Rezoning Transportation Analysis

Petition Number: 2023-033

Reviewer: Natalie King
Natalie.King@charlottenc.gov
980-417-0206

Date	Description
7-26-23	First Review (IW)
08-24-23	Second Review (NK)
9-20-23	Third Review (NK)
10-25-23	Fourth Review (NK)

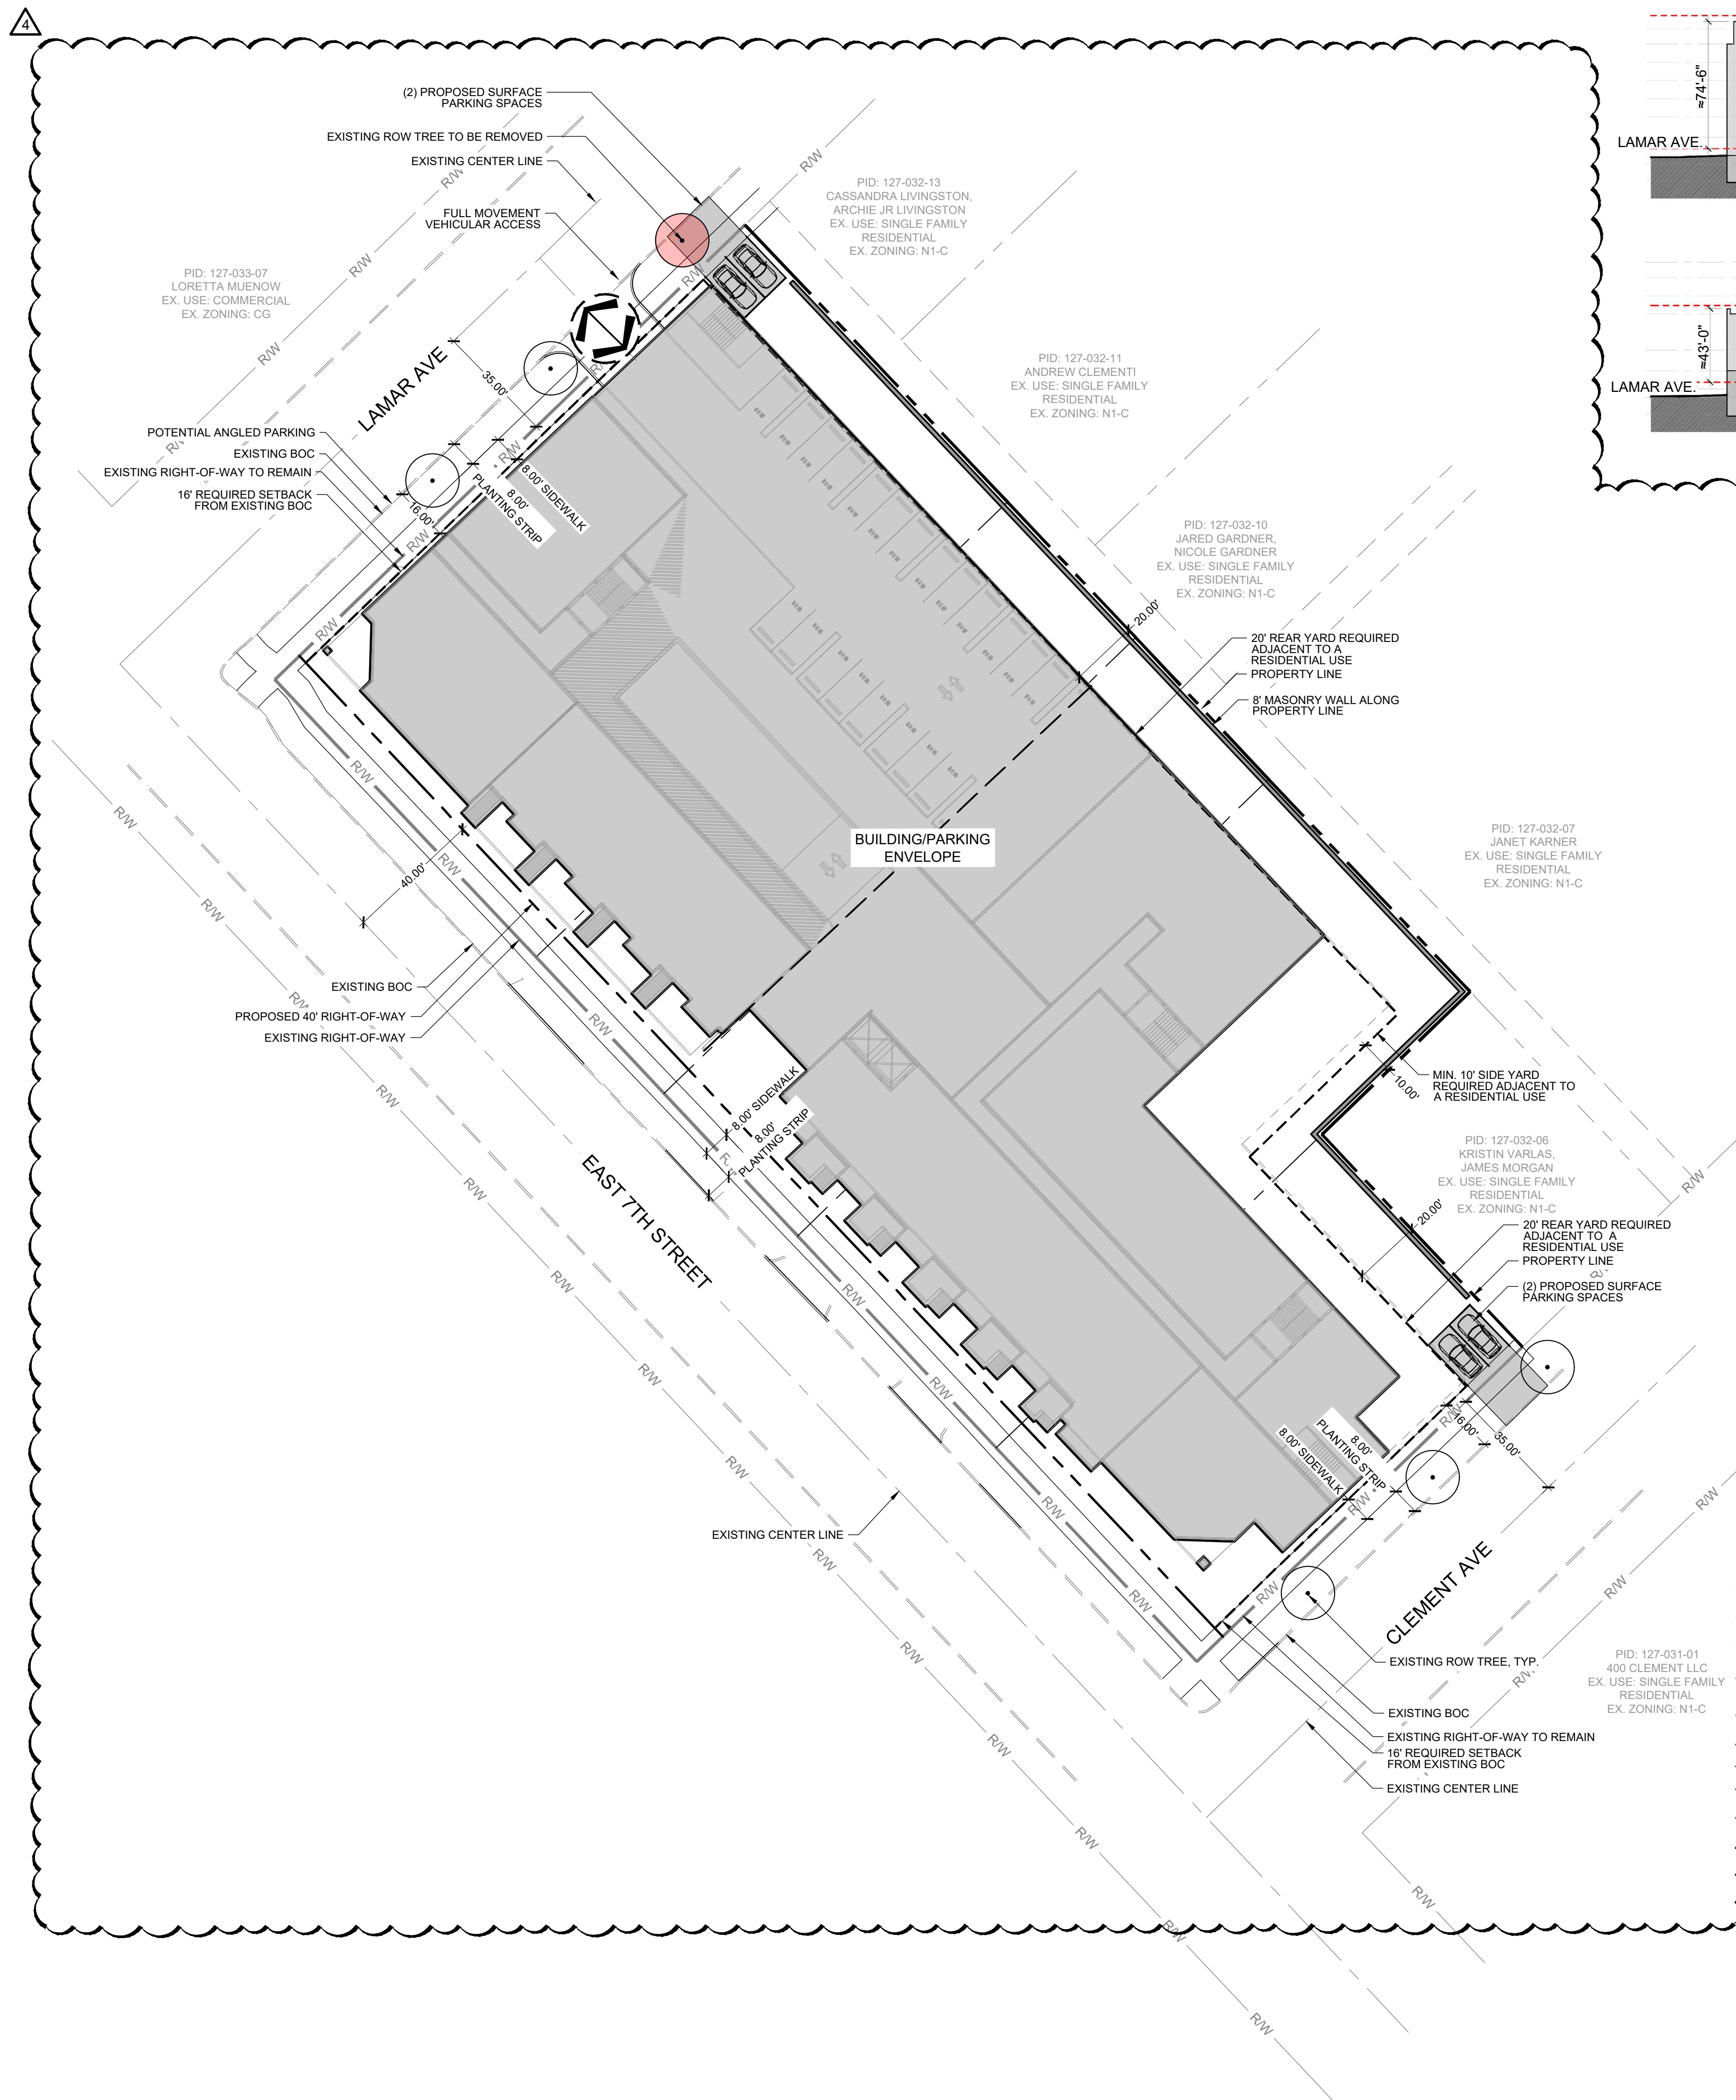
Clarifying Comment 9-20-23: Remove the additional parking spaces on Clement and Lamar Ave. Access to parking spaces is not allowed over a streetscape. This access would be considered a driveway and would be required to meet minimum driveway standards including geometric design, spacing, and internal stem requirements.

13. **New Comment 10-26-23:** Revise site plan to show future curb line located 27’ from centerline of E. 7th Street. Preservation of future curb line allows installation of bicycle facilities in the future to include buffered bicycle lanes. Preservation of space for future buffered bicycle lanes meets Council-adopted Charlotte BIKES policy. Current plan revision removed preservation of space for bicycle facilities and does not accommodate any form of future bicycle facilities.

15. **New Comment 10-26-23:** Remove reference to potential angled parking. Angled parking not permitted within the public right-of-way. Petitioner may work with CDOT during the permitting process to stripe parallel parking if desired.
